Application Ref:	3/2025/0880			 Ribble Valley Borough Council www.ribblevalley.gov.uk
Date Inspected:	13/11/25	Site Notice:	13/11/25	
Officer:	BT			
DELEGATED ITEM FILE REPORT:				REFUSAL

Development Description:	Retrospective application for single storey side extension.
Site Address/Location:	26 Whalley Road, Langho, BB6 8EJ.

ROOF PLAN

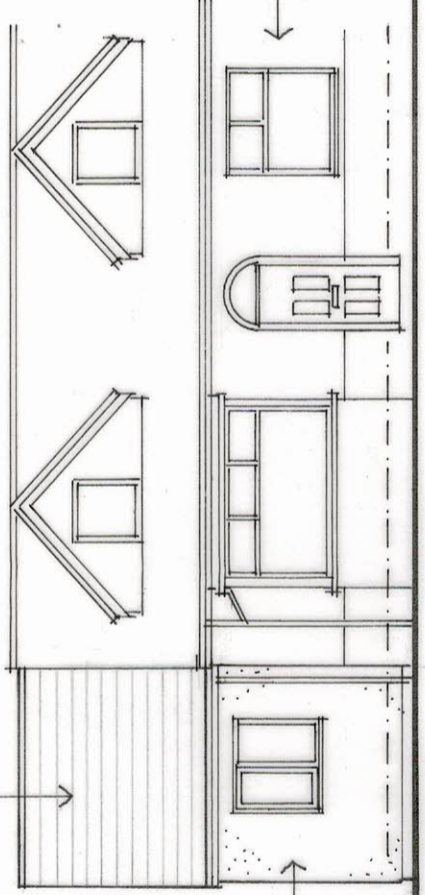
In contrast, the front roof slope of the unauthorised extension incorporates a minimal set down with its front roof slope and ridgeline being almost flush with the principal roof slope and ridgeline of the application property. In addition, whilst a 0.5 metre set back has been retained to the extension's front elevation, the front eaves and soffit of the extension overhang its front elevation which in turn diminishes its set back from the application property's principal elevation. As such, the unauthorised extension, by virtue of its roof symmetry and overall scale, bulk and massing reads as an over dominant, unsympathetic and incongruous addition to the application property and existing street scene.

FRONT ELEVATION

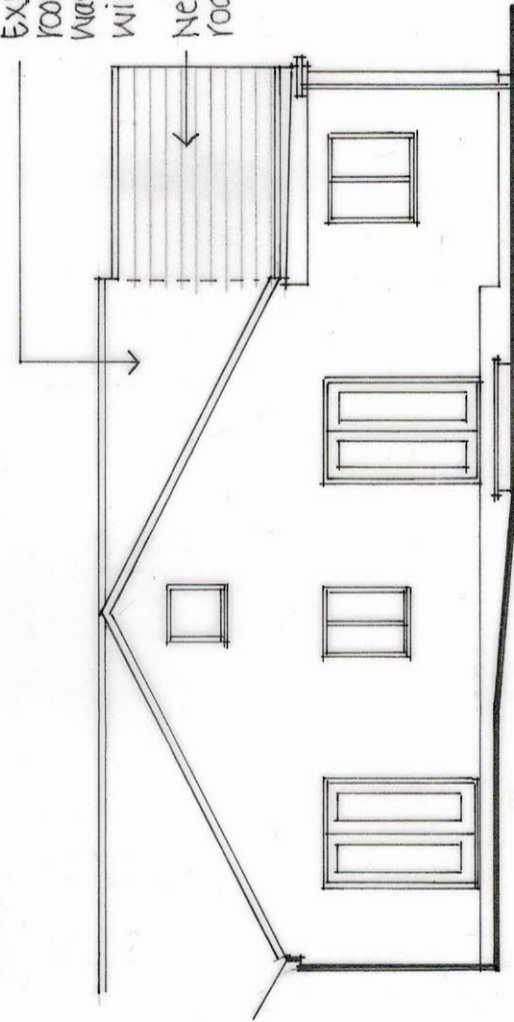
Furthermore, the existing roof tiles in place on the front roof slope of the extension are currently at odds with both the design and colour of those in place on the principal roof slope of the application property. Whilst it is stated that reclaimed roof tiles are to be incorporated to the front roof slope of the extension to address this visual imbalance, it remains doubtful as to whether an exact match could be achieved between any reclaimed roof tiles sourced and those currently in place on the principal roof slope of the host property. Similarly, the existing roof tiles in place on the rear roof slope of the extension comprise a different colour detail to the existing roof tiles in place on the rear roof slope of the application property and whilst it is proposed to power wash the tiles on the host property to tone in with the tiles on the extension, it remains unclear as to whether this would provide an effective solution to the current visual imbalance in place.
